Re: Unit #2, Second Tee Business Park

The Development Review meeting discussed this project this morning and please revise the site plan to address the following:

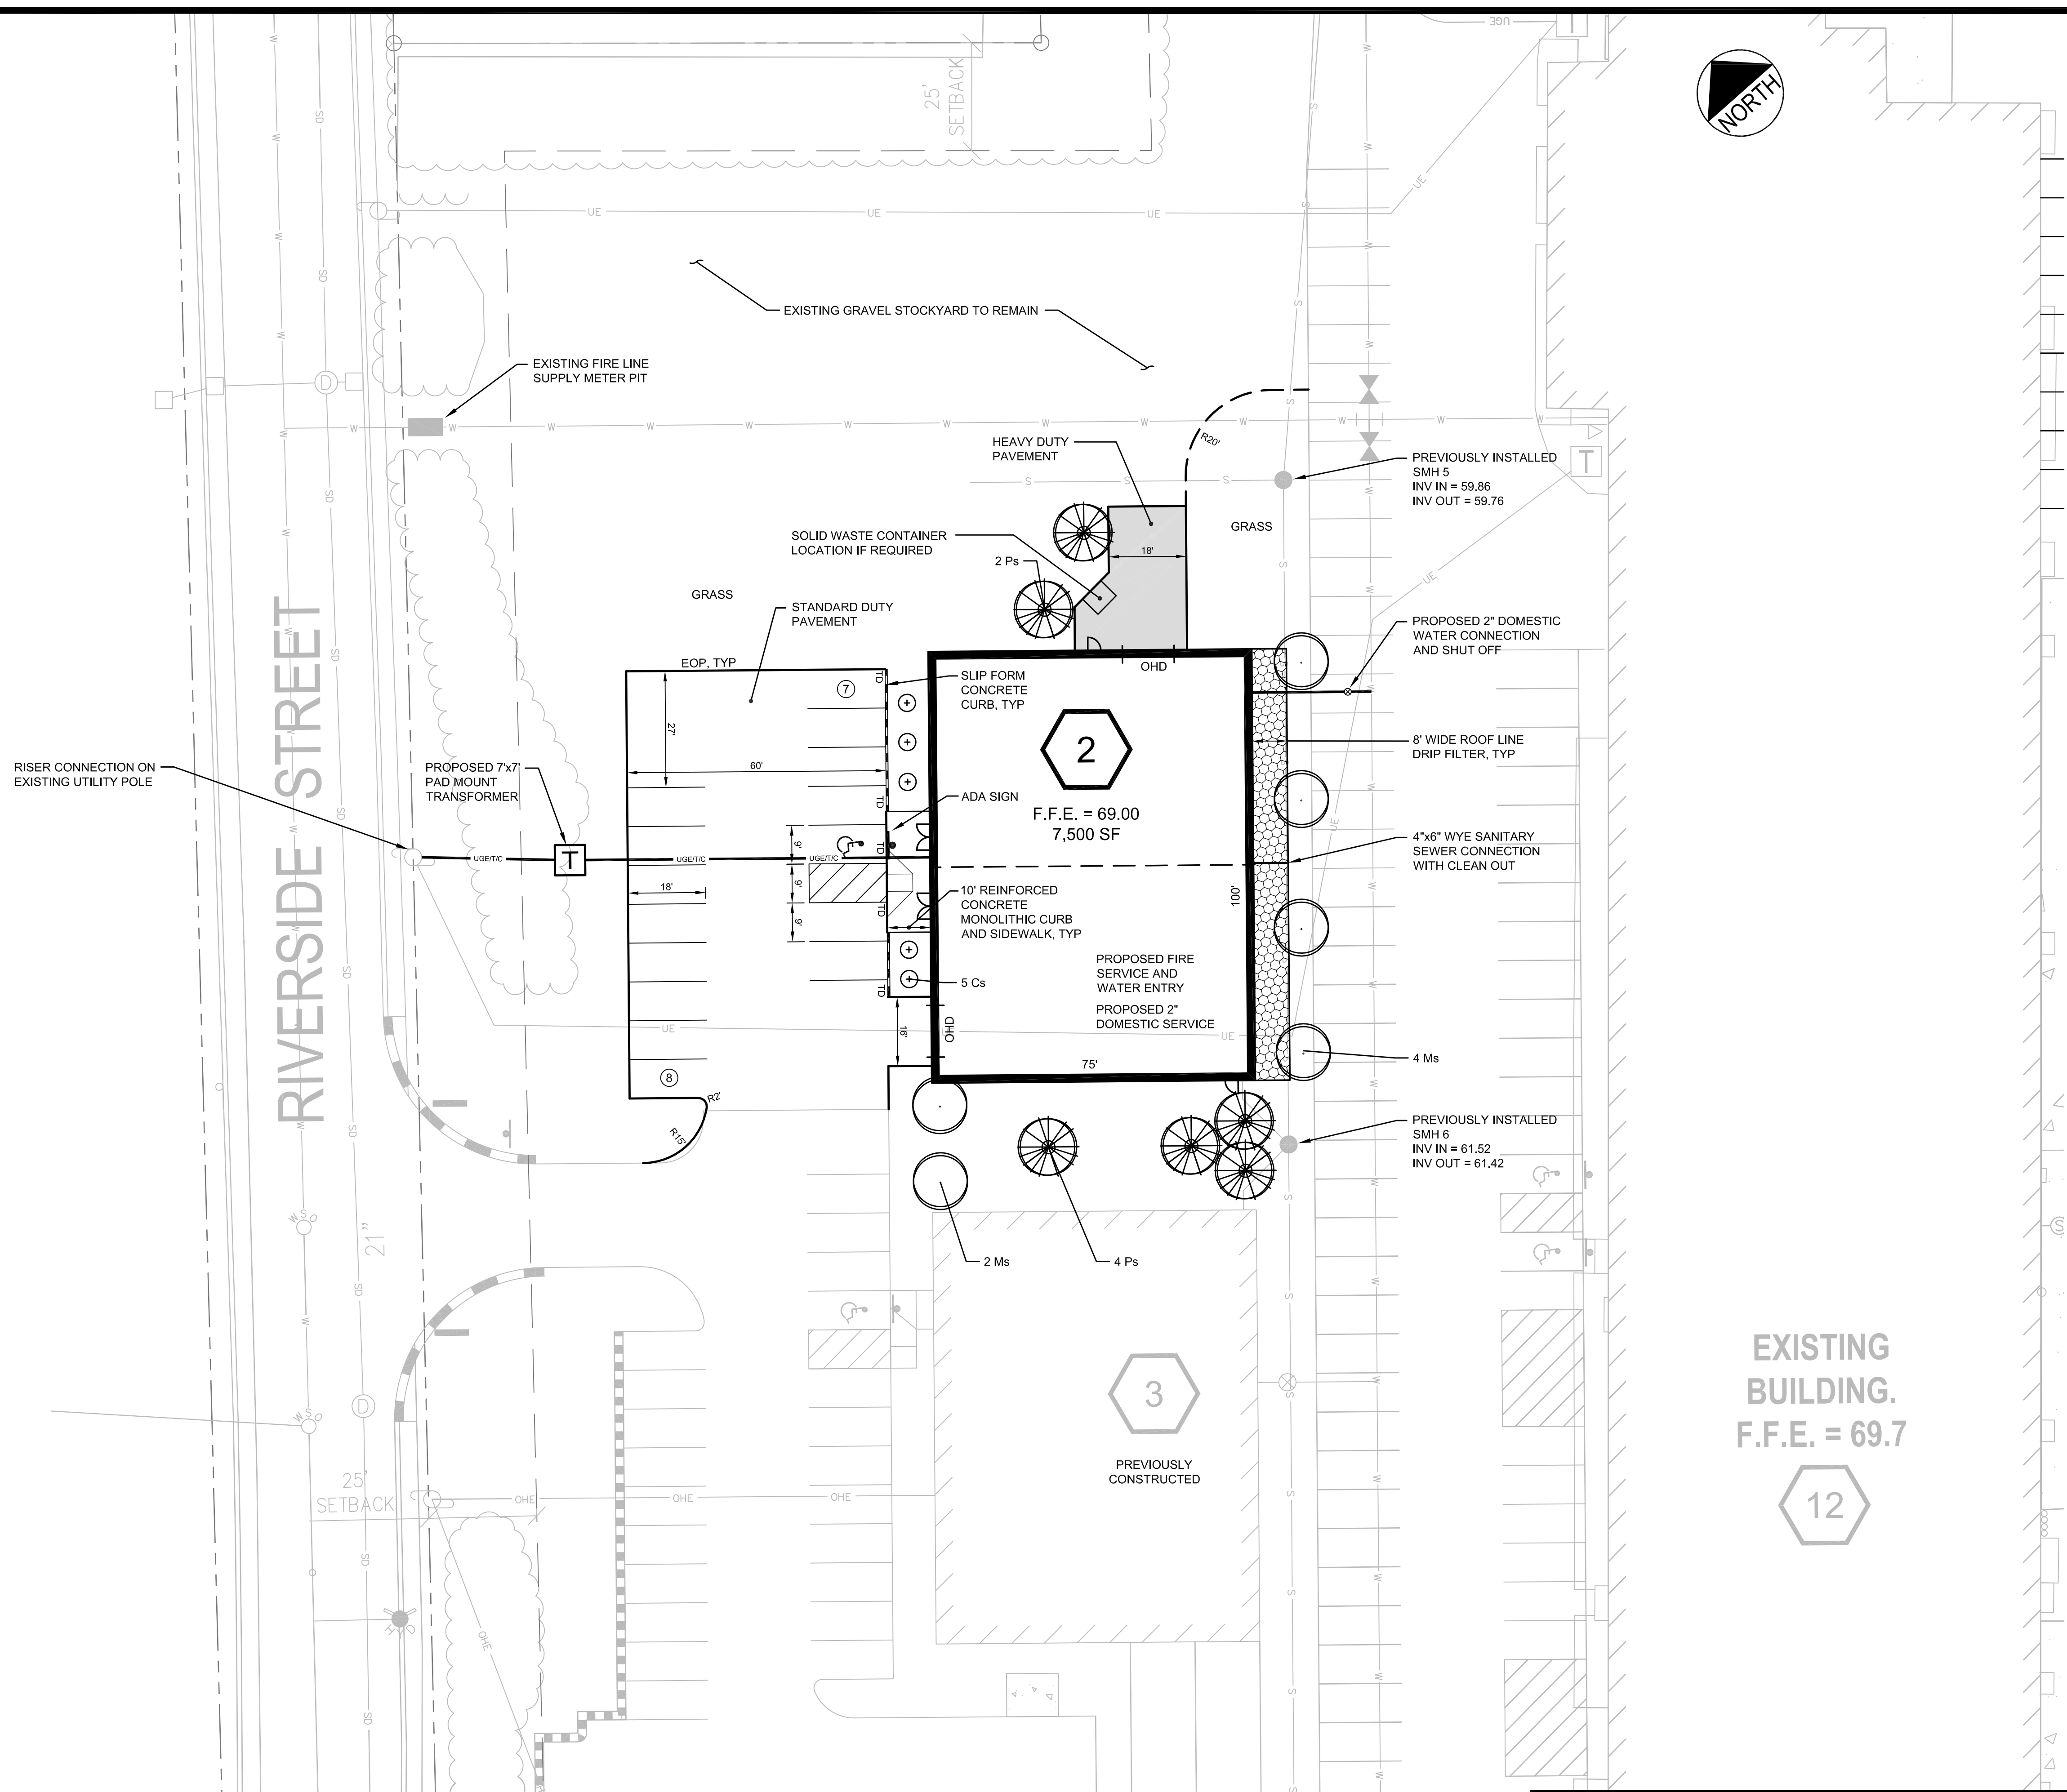
- Tom Errico, Traffic Eng reviewer, has requested that a sidewalk connection be provided along the site driveway between Riverside Street and the proposed building;
- Please show final condition for the loading area as from Tee Drive, showing a connection to Tee Drive that is suitable for loading and restriping of Tee Drive (re parking) as necessary;
- Please show the 2 required bicycle parking racks;
- Please show where snow storage will be located;
- The Peer Engineer comments sent to you a few days ago.

Do you have any photos of the area between the heavy duty concrete and Tee Drive in the area you have marked as "existing gravel stockyard" which would be the route for vehicles loading/unloading into this site?
